**STATUTORY CONSULTATION UNDER SECTION 42 OF THE PLANNING ACT 2008
INFRASTRUCTURE PLANNING (ENVIRONMENTAL IMPACT ASSESSMENT)
REGULATIONS 2017.**

IMMINGHAM GREEN ENERGY TERMINAL

This is the response of North East Lincolnshire Council (NELC) to the Statutory Consultation in regard to the above NSIP project for the Immingham Green Energy Terminal Development. The applicants Associated British Ports (ABP) and Air Products (AP) entered into pre-application discussions with NELC in 2021 to seek the advice of the Local Planning Authority (LPA) and input from internal consultees over key issues. This has been a collaborative process between the LPA and the applicant.

FIGURE TITLE
Site and Surrounding Environment
Sheet 3 of 7

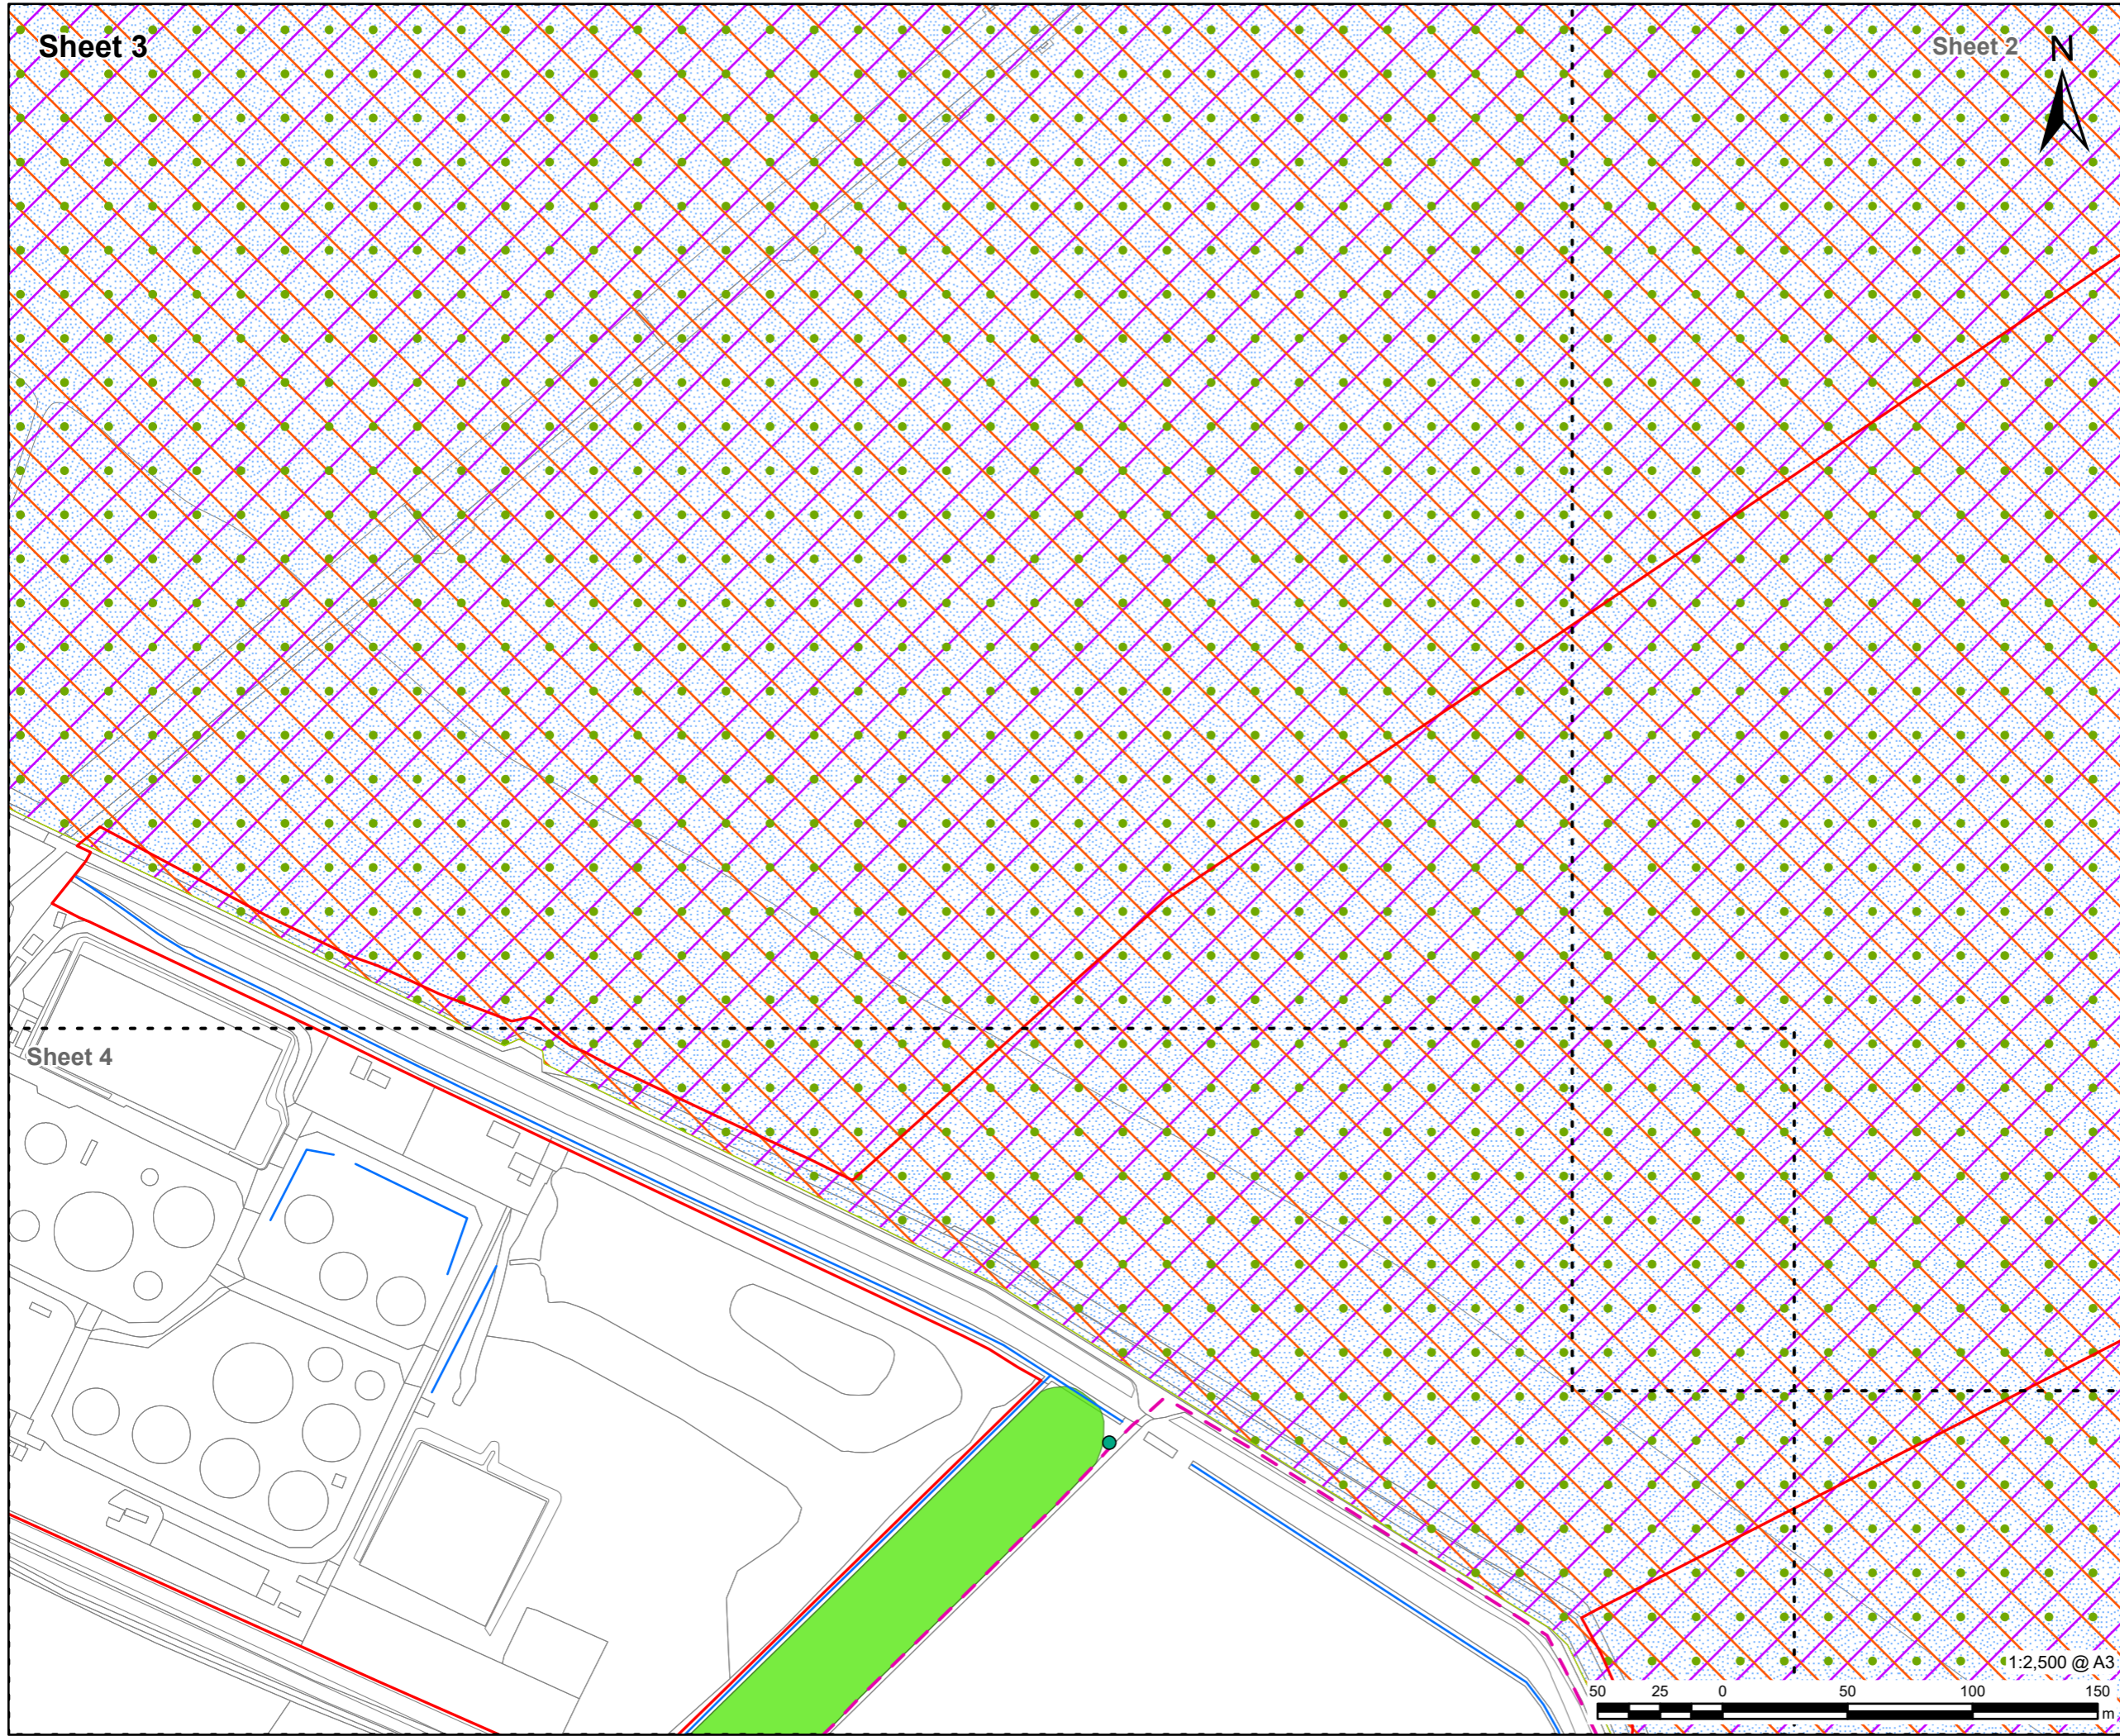
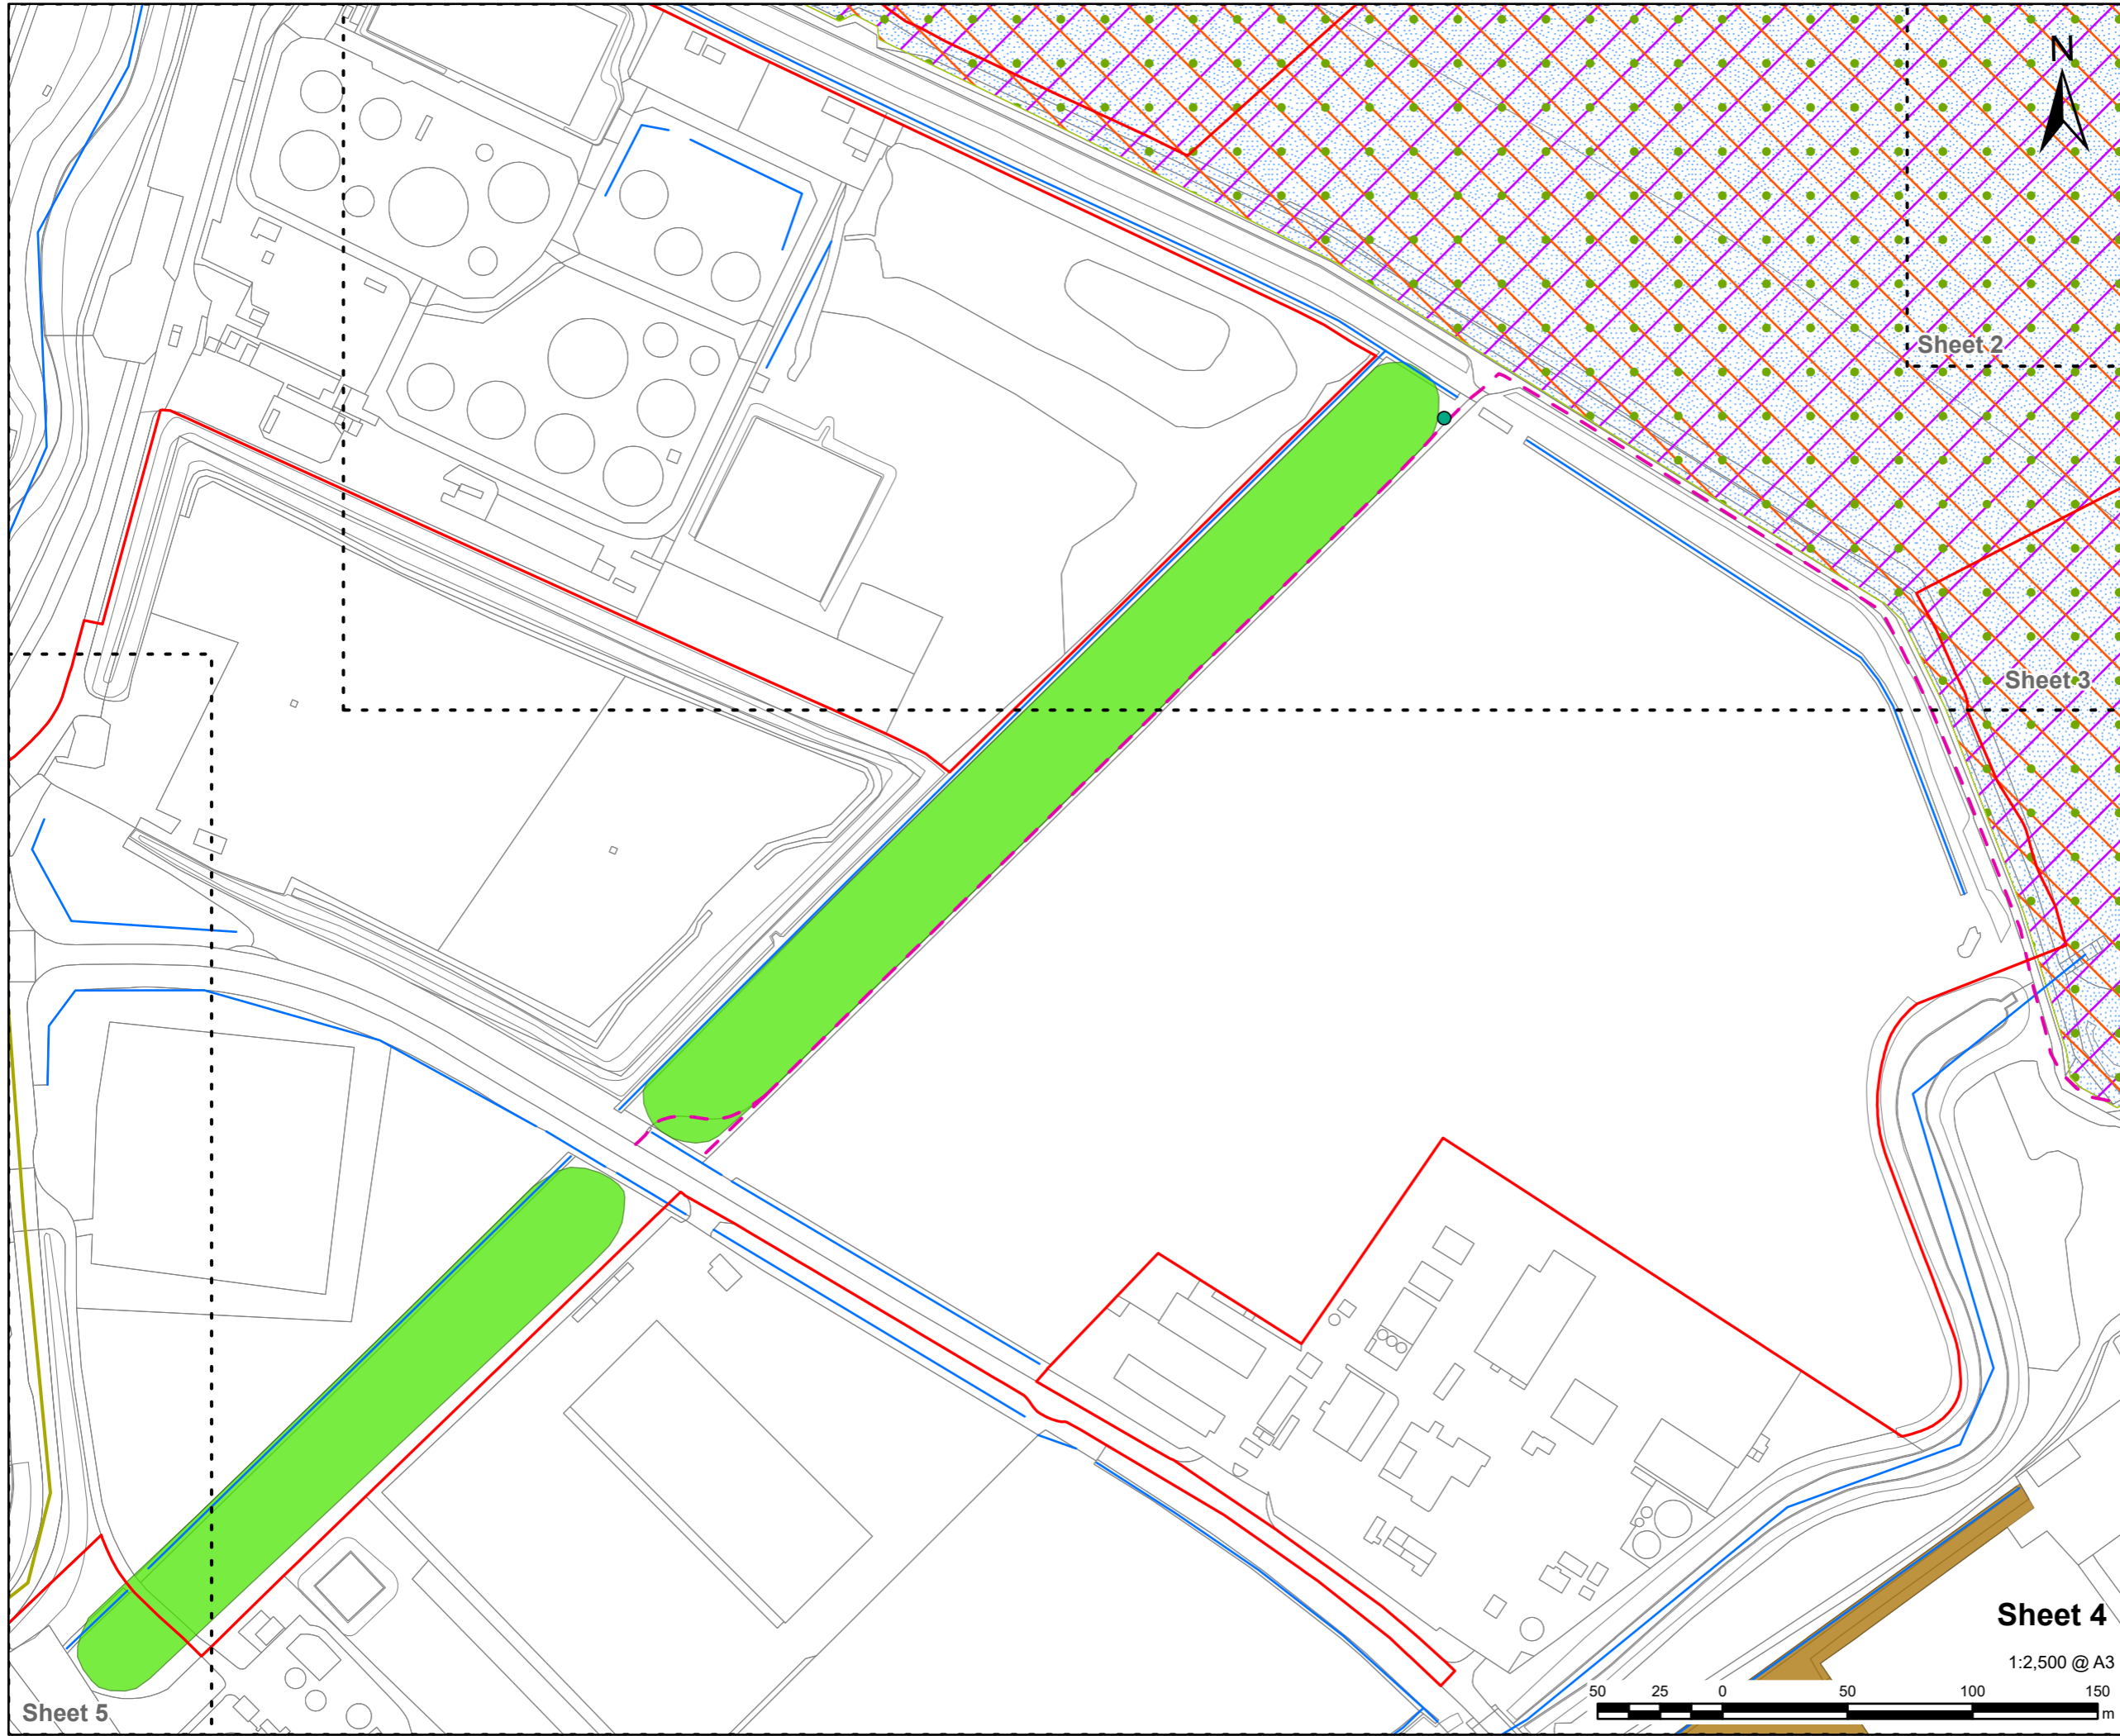
Regarding the woodland known as Long Strip that will be impacted by removal, Paragraph 2.3.24 of the PEA appendix 8.B, states that it represents 'Long Established Woodland', the land having been wooded for at least 130 years. The loss of mature deciduous woodland, which is a UK Priority Habitat, will require bespoke compensation as there are limited opportunities for replacement planting within the operational Site Boundary.

There is mostly a continuous line of trees or hedgerow along Manby Road/Kings Road and continuation of that within the landscape plan would be beneficial, particularly in connecting the remaining parcel of Long Strip wood, which is, as Chapter 8 Nature Conservation Terrestrial Ecology identifies, otherwise isolated and of Borough nature conservation value.

We await the updated bat survey to establish use of the woodland but note that a roost within a central tree has been confirmed and moderate roost potential is spread throughout the woodland. If the confirmed tree roost is to remain it would be impacted by the reduction of woodland.

Whilst I have no principled issue with the tree report and information presented, it is all very good and informative. I note that a 3rd of the Cat A trees will have to be felled, which is a far from ideal situation. They are proposing to reduce the width of the northern section of the woodland by half. A

plan has previously been requested that details the pipeline, the service road with the tree constraints also shown so it is clear which trees will be removed but also what the impact will be on those that are detailed to be retained. The northern section of Long Strip would be reduced by more than 50% and as such the above plan is critical to fully understanding that impact on the protected woodland.
